From: Amanda Scholes on behalf of Planning.Responses
Sent: 22 February 2021 11:36
To: Planning Scanning
Subject: FW: Planning Consultation on: CM/53/20/PL

Without prejudice to the requested withdrawal of this application I would re-iterate that there are concerns regarding the proximity of the proposed dwelling at plot 4 to the side boundary with 30 Appletree Walk. The 45 degree rule is accepted as more relevant to an extension setting, but it serves to demonstrate that the outlook from rear windows is important and is a base for assessing these relationships. The Design Guide includes a section on backland development which is also relevant and states 'Backland developments should demonstrate an understanding of any potential effects on the character and amenities of the neighbouring urban area. As a general rule, backland developments should be subservient to existing properties, and their layout should seek to maximise the outlook of neighbours. Proposed building scales and development densities should address the characteristic urban development patterns of previous backland developments in the area.'

SITE PLAN
SCALE 1:500 @ a3

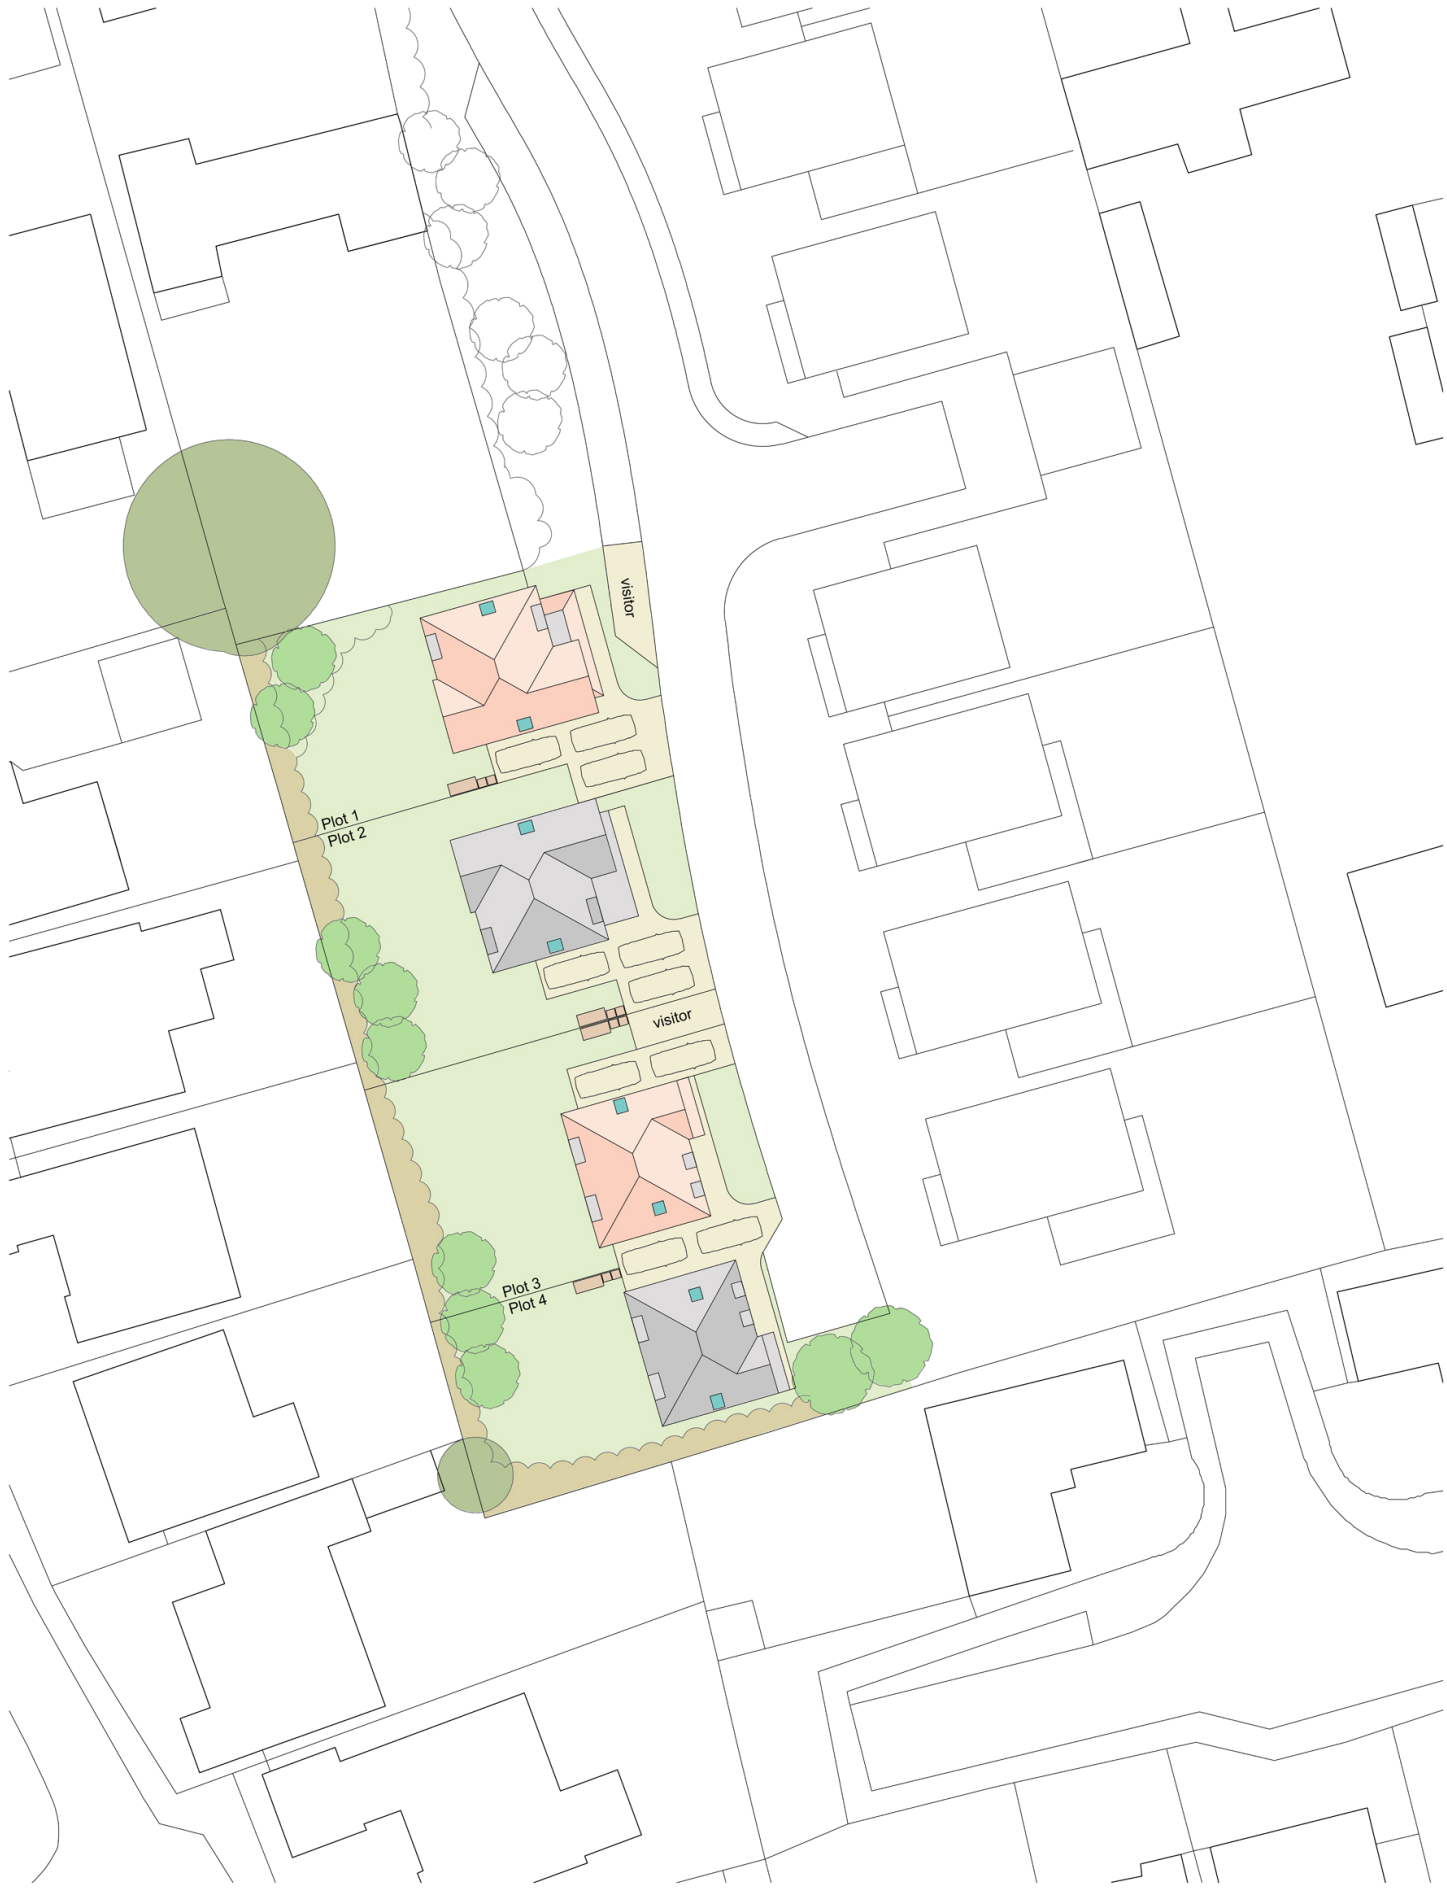
Plot 4 does not accord with this guidance. It cannot be described as maximising outlook or subservient given its height and proximity to the boundary. The gap to the boundary should be dimensioned and increased, or the height of the dwelling reduced adjacent to the boundary. In my view, although the garden to no 30 may receive an acceptable amount of sunlight/daylight from the south and west the dwelling would have an overbearing impact on the users of this garden since it extends to approximately half of the garden length.

I have spoken to our drainage engineer and there is an issue that any drainage is likely to be dependant on the adjacent site Scyld and it is not clear from the details submitted that the developers of that site would be willing to allow your client the opportunity to utilise any drainage agreed for their site. It seems unlikely that this can be resolved quickly so I would suggest that the application is withdrawn to allow time for discussion between the relevant parties. The application expires tomorrow so I would be willing to agree to an EOT until 18-02-2021 to allow you time to discuss with your client, but this would need to be agreed with you by return.
If the identified tree, drainage and plot position issues can't be resolved in the short term the application is likely to be refused.

At this stage no serious consideration has been given as to how to drain surface water from the site. Within the Flooding and Drainage Statement the applicant states that they are happy for this to be dealt with via condition, understanding the necessity for winter groundwater monitoring and infiltration testing. The applicant expects to drain the site via soakaways in the property gardens, or in shallow soakaways and permeable paving if groundwater is evidenced at shallow depth.

Ground investigation results from neighbouring sites evidence that infiltration is highly unlikely to be suitable at this location due to the presence of high groundwater (0.3mbgl). Therefore, a connection to the watercourse along

Horsemere Green Lane is likely to be required. It is unclear how this will be possible as the site is land locked and the shallow falls across the site to the watercourse. We note that the site access is via the proposed development at Scyld. We would therefore suggest that the two sites will require a drainage scheme that works together, however the drainage scheme for Scyld as it currently stands would not have capacity to drain any additional water.

Therefore I wish to lodge a holding objection to this application.

To overcome our holding objection we request that the applicant submits details of how they propose to drain the site in a worst case/no infiltration scenario. If this information is not provided prior to determination it is likely that the layout will unduly bias the design of surface water drainage and could result in flooding being increased elsewhere.

Would it be possible to have a quick chat about plot 4? We are looking to withdraw and redesign this plot – potentially to a meaningful 1.5 chalet style wot reduce the eaves on the boundary and move the side elevation off the boundary.

Drainage: we have liaised with our client and the drainage engineer and they have confirmed that the application site benefits from rights to connect into the drainage at Scyld and that these rights were secured when the right of access to the application site across land at Scyld was agreed. We trust this clarification is sufficient for the Council's Drainage Engineer's purpose.

Plot 2: requires only a minor adjustment to the footprint – this work is underway and will further inform the tree survey.

Plot 4: we would like to clarify whether the 45 degree rule is strictly relevant to the relationship between plot 4 and the neighbouring property at 30 Apple Tree Walk; there would be a significant gap between the rear of no. 30 and the proposed house at plot 4 as shown on the extract site plan below. Our understanding of the 45 degree rule is that it applies where there the development would result in a continuous built form along the side of an existing dwelling, and is traditionally applied to assessing the impact of an extension on an existing dwelling. Due to the orientation of the properties no. 30 will continue to receive uninterrupted sunlight/daylight from the south and west as the proposed unit is positioned to the north and will also enjoy a large gap between its rear elevation and side elevation of plot 4. Based on this information it is considered that plot 4 would have an acceptable relationship with no. 30 Apple Tree Walk.
